# Southampton to London Pipeline Project

Applicant's Comments on Responses  
submitted for Deadline 5

Application Document: 8.86

Planning Inspectorate Reference Number: EN070005

Figure 1: Plans Showing Construction Compounds and the area they serve

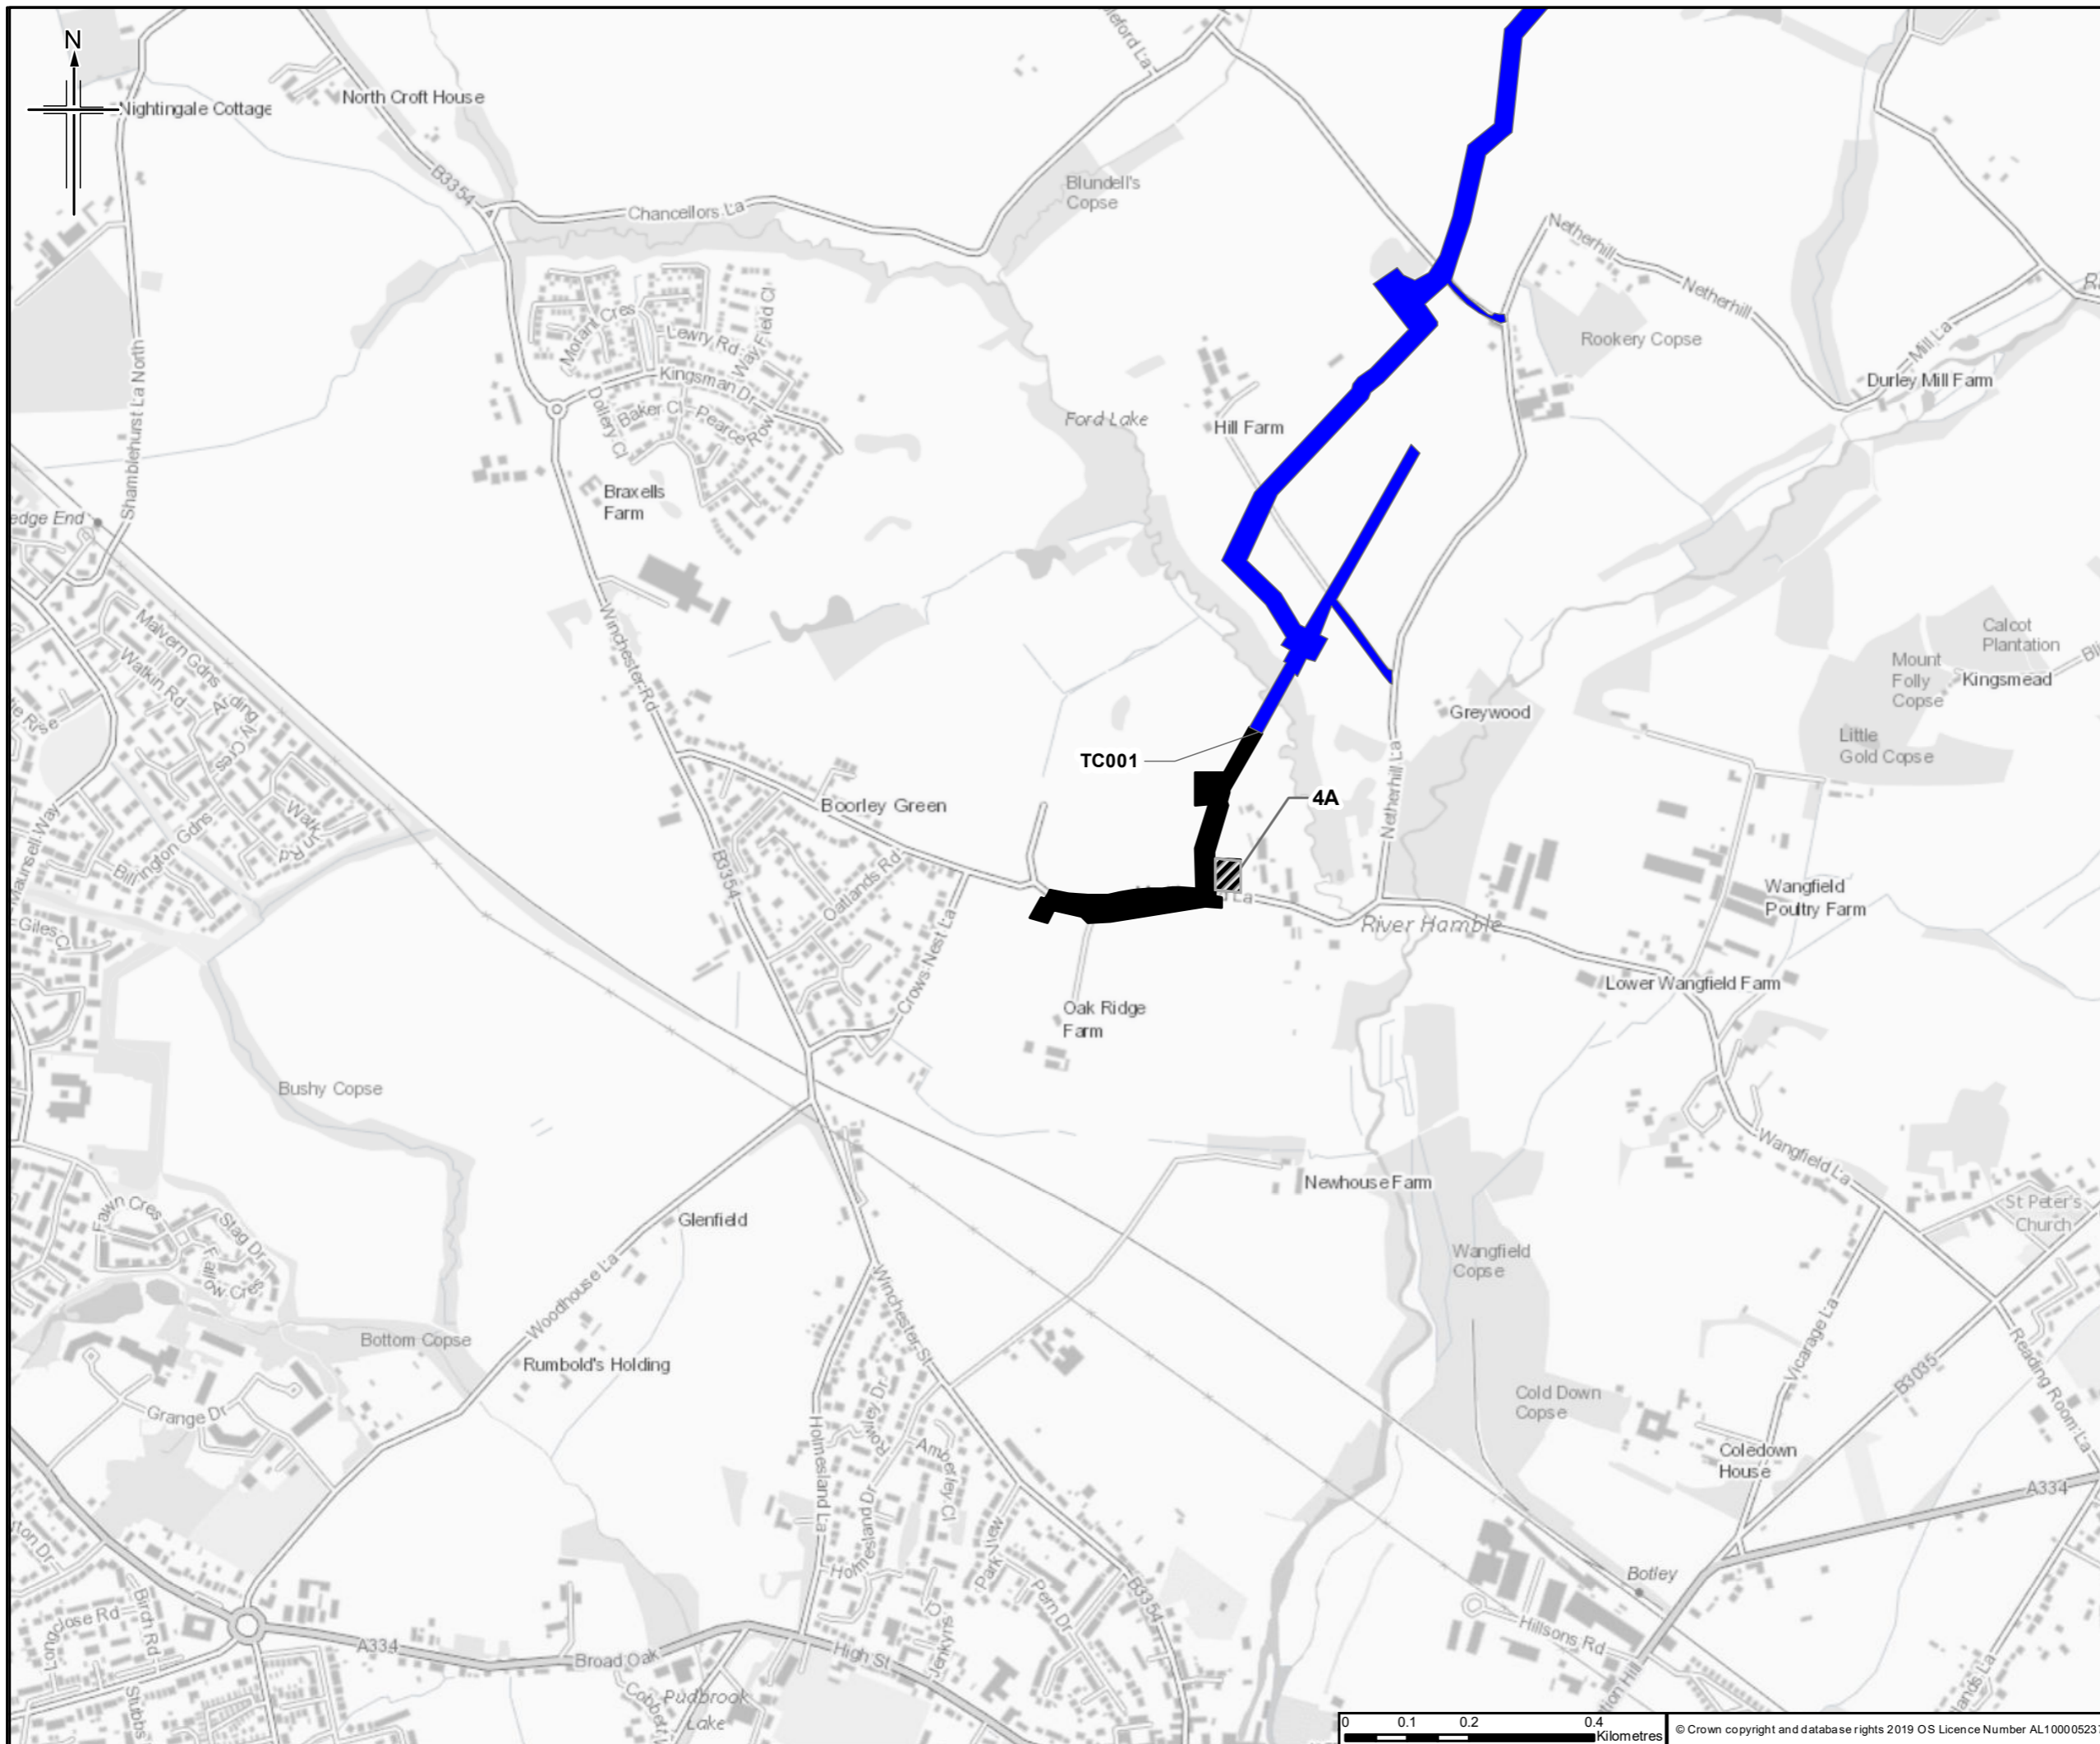
1.15.1	Construction Programme	<p>1.1 The Applicant submitted plans at Deadline 4 in response to Hearing Action Point 23 (ISH3-23). These show the relationship between each of the construction compounds and the area which they serve (see Figure 1 in <a href="#">REP4-033</a>).</p> <p>1.2 W8 – The Applicant is surprised that Rushmoor BC is stating a preference for the works in the Cove Brook Flood Storage Area to take place in the winter months when the risk of flooding is at its highest.</p> <p>1.3 Rushmoor BC's statement appears to be addressing only ecological concerns while the Applicant has the responsibility to consider all impacts of its project.</p> <p>1.4 The Environment Agency believes that works in the Flood Storage Area could put the local residents of Rushmoor at a greater risk of being impacted by flooding and has insisted the works are undertaken in the drier weather and the Applicant has committed to this.</p> <p>1.5 In addition, working in the winter months would lead to a greater impact to soil condition and storage which would likely lead to an extended period of disturbance for users of the SANG.</p> <p>1.6 Rushmoor BC has confirmed in a meeting with the Applicant (27 February 2020) that it does not wish to have works undertaken in the Flood Storage Area or elsewhere in</p>

REP5-044 – Rushmoor Borough Council Comments appertaining to ESSO's Outline CEMP, LEMP, CTMP and CEP		
WR Para Ref	Point raised	Applicant response to point raised:
		Southwood Country Park during the winter months and this is reflected in the Site Specific Plan ( <b>Document Reference 8.60 (2)</b> ).
